Future City.G.Mansfield.  
Reference: 4113758  
Phone: 02 49742767  
Your contact: Andrew Hartcher

**CRAWFORDS AMMONIUM NITRATE STORAGE AND DISTRIBUTION FACILITY,  
158 OLD MAITLAND ROAD, SANDGATE (SSD-5119)**

I refer to the Department's letter of 30 January, 2013 inviting Council to comment on the Environmental Impact Statement (EIS) prepared by Environmental Resources Management Australia in support of the above development application.

Figure 4: Individual Fatality Risk Contours

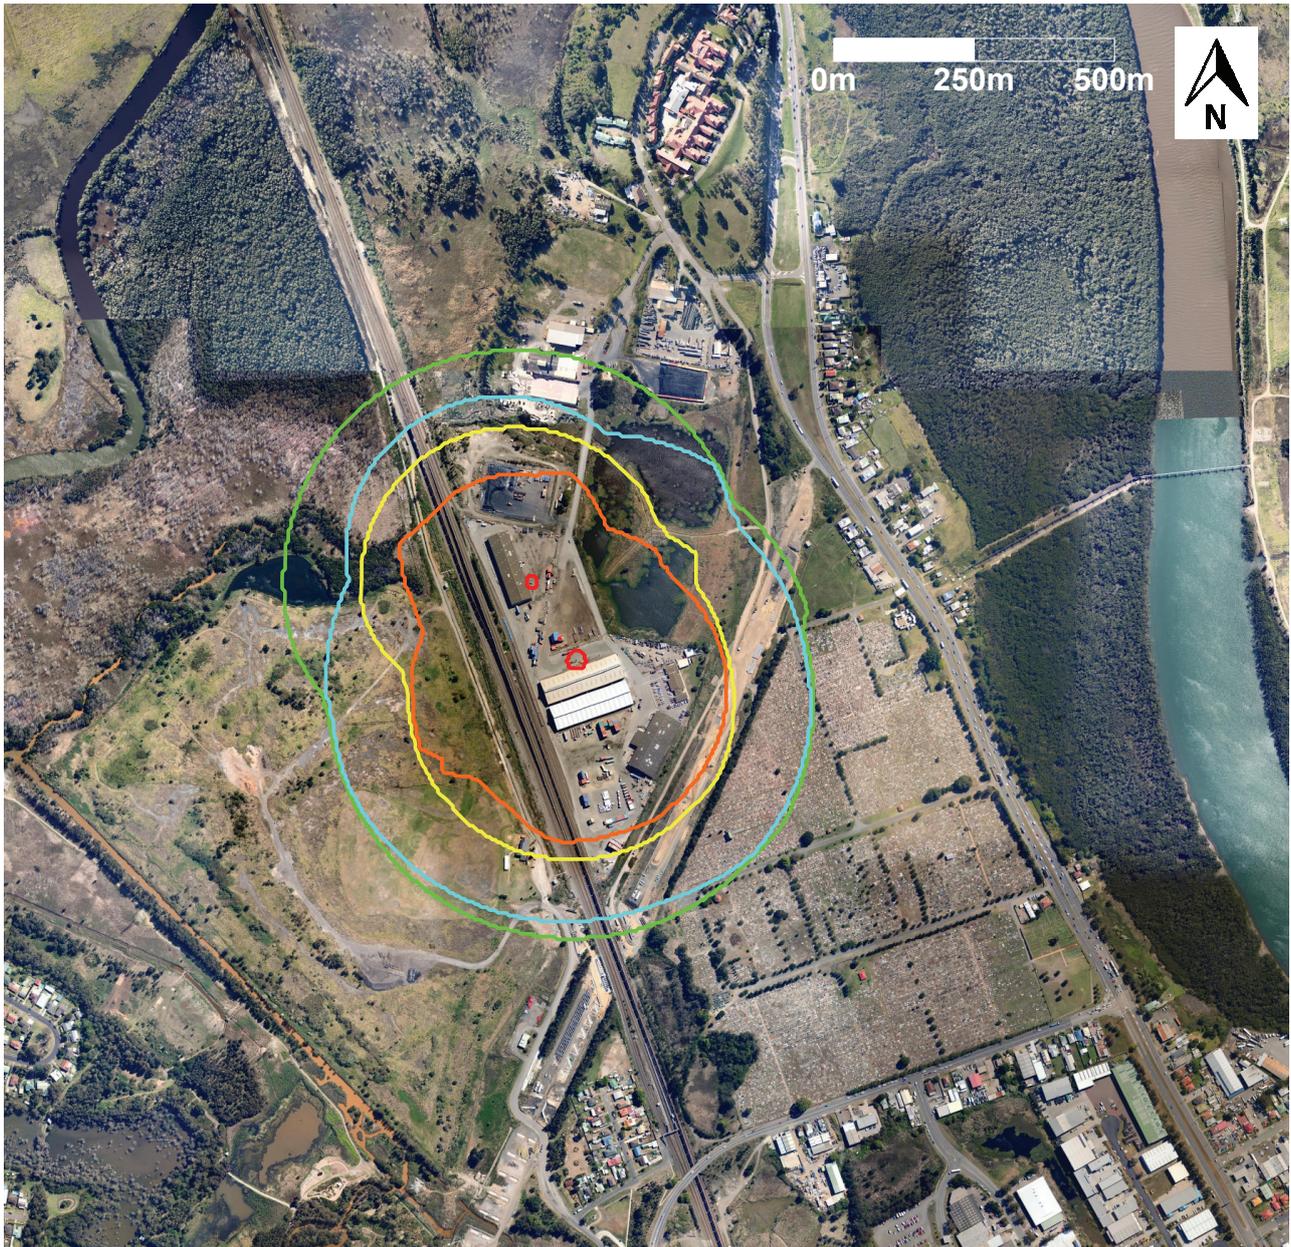
The proposed storage quantities stated in the Hazard Analysis (HA) prepared by Health & Safety Essentials differ from those indicated in the EIS (and in other supporting reports).

As a result of the above discrepancies the incident scenarios in the HA are based on loaded shipping containers being stored only in the compound of Shed C. It is noted that the compound of shed B is located immediately northeast of the Newcastle Golf Practice Centre which is located on part of the adjacent Council Astra Street landfill site. This is particularly relevant given the HA already acknowledges that in relation to the above golf driving range the proposed development does not comply with the quantitative criteria for 'sporting complexes and active open space areas' specified

Given the above circumstances, it is requested that the applicant be required to submit an amended HA, based on the correct storage quantities that demonstrates, as required by the Director General's requirements for the Preliminary Hazard Analysis, that the proposal will comply with the criteria set out in HIPAP No 4.
